From: Alison Meeus [REDACTED]
Sent: 27 June 2018 13:07
To: Chelsey Carter
Cc: Juan Baeza
Subject: RE: FW: Spindlewood

I am dealing with a re-consultation of planning application WA/33/18 however I am unable to respond fully as there is still information missing that I require. The applicant has now provided swept path diagrams for a refuse vehicle but I am still unsure of the visibility splays and the actual speed of the road. I asked for a speed survey and visibility splays taken to the nearside kerb. Will these be provided as I have no other comments other than the ones I made previously asking for these things.

Drawing No.
DPA 13

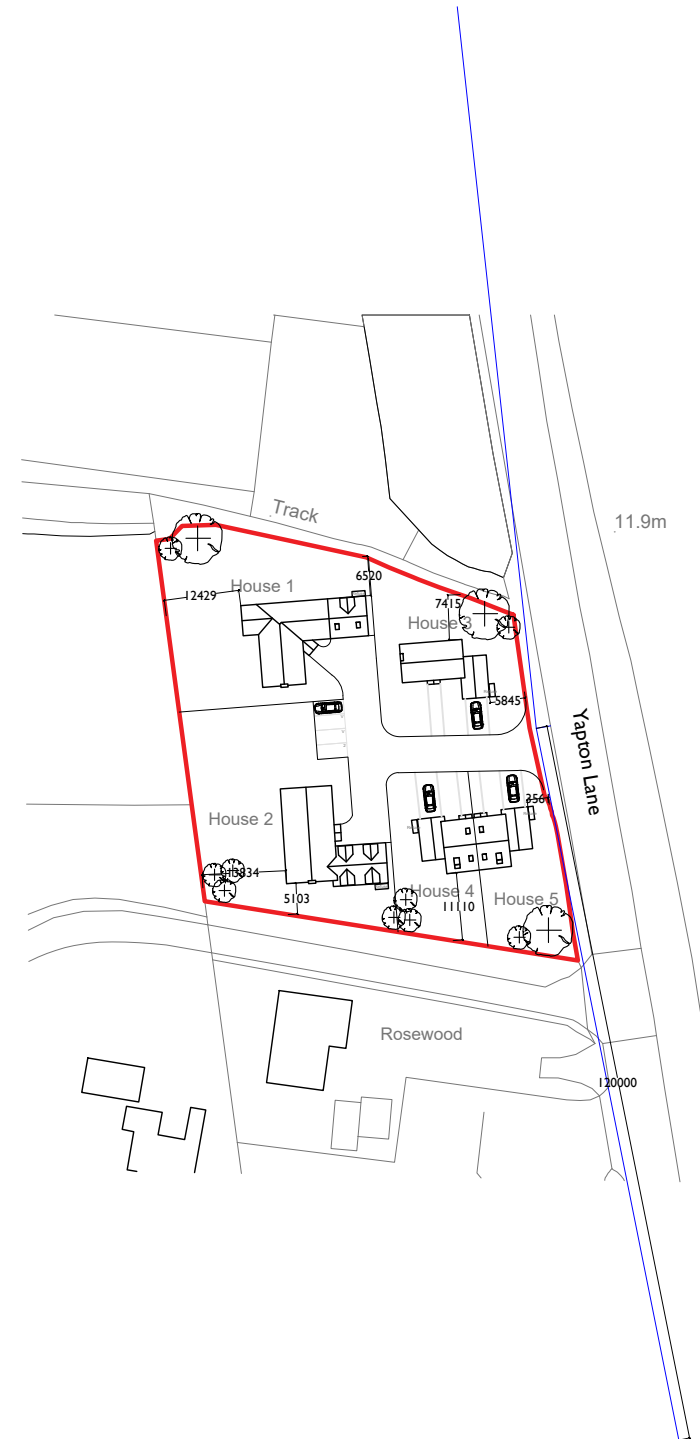
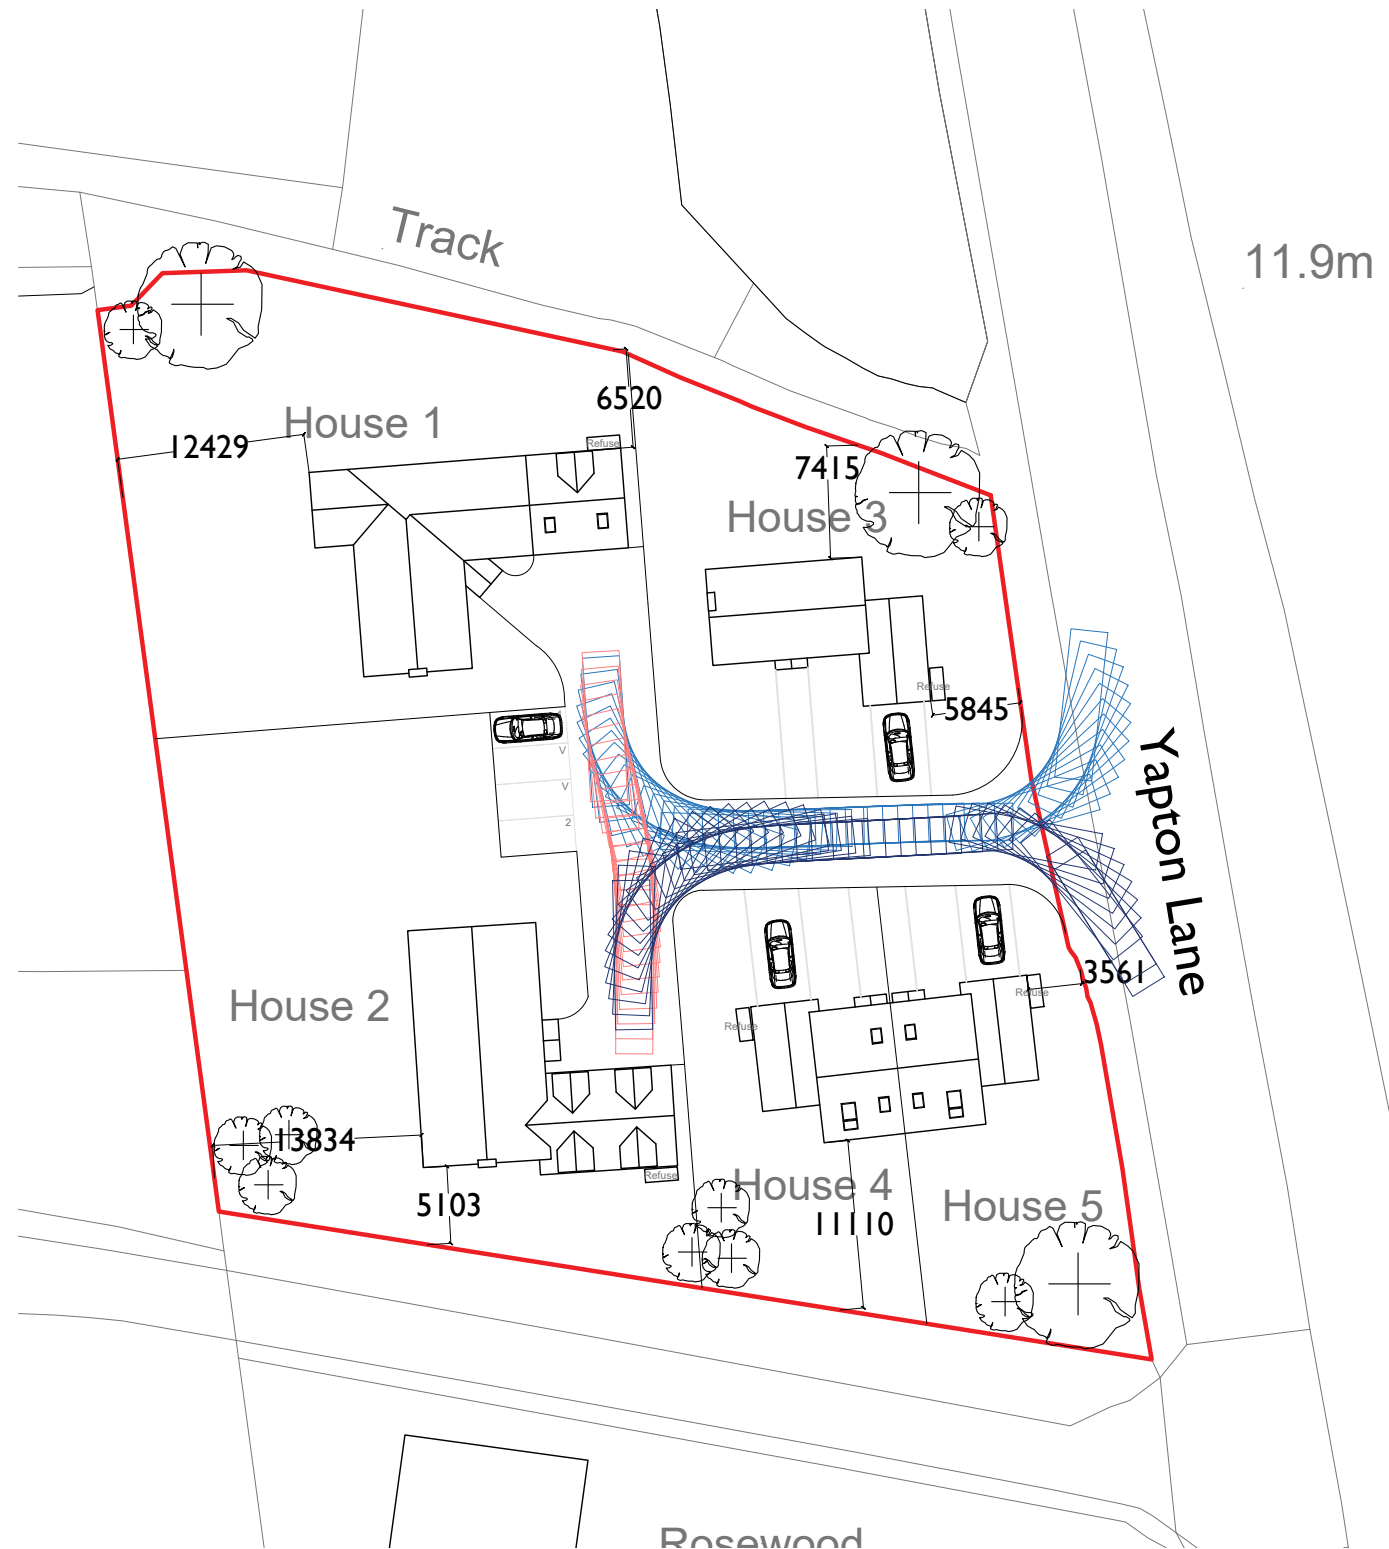
Many thanks for this. Based on this drawing DPA 13 – Visibility splay, we can accept the access in this position with these splays. One other question, are the splays drawn to the nearside kerb or off set by 1m? It seems that the northern splay is to the centre line? This would be acceptable as it is not the leading splay but I do need this confirmed. Do the splays go over third party land at all? It doesn't look like they do but can you confirm this please?

I can see a blue line on the plan but it doesn't have any annotation on it to say its 120m. Furthermore is this set back 2.4m or 2m? This should be shown as otherwise its open to interpretation.

If the 120m visibility can be provided in both directions then this will be acceptable for a 40mph road if set back 2.4m and no speed survey will be required.

Please find attached DPA 13 – Visibility Splay. This is show with dimensions of 2.4m and 120m.
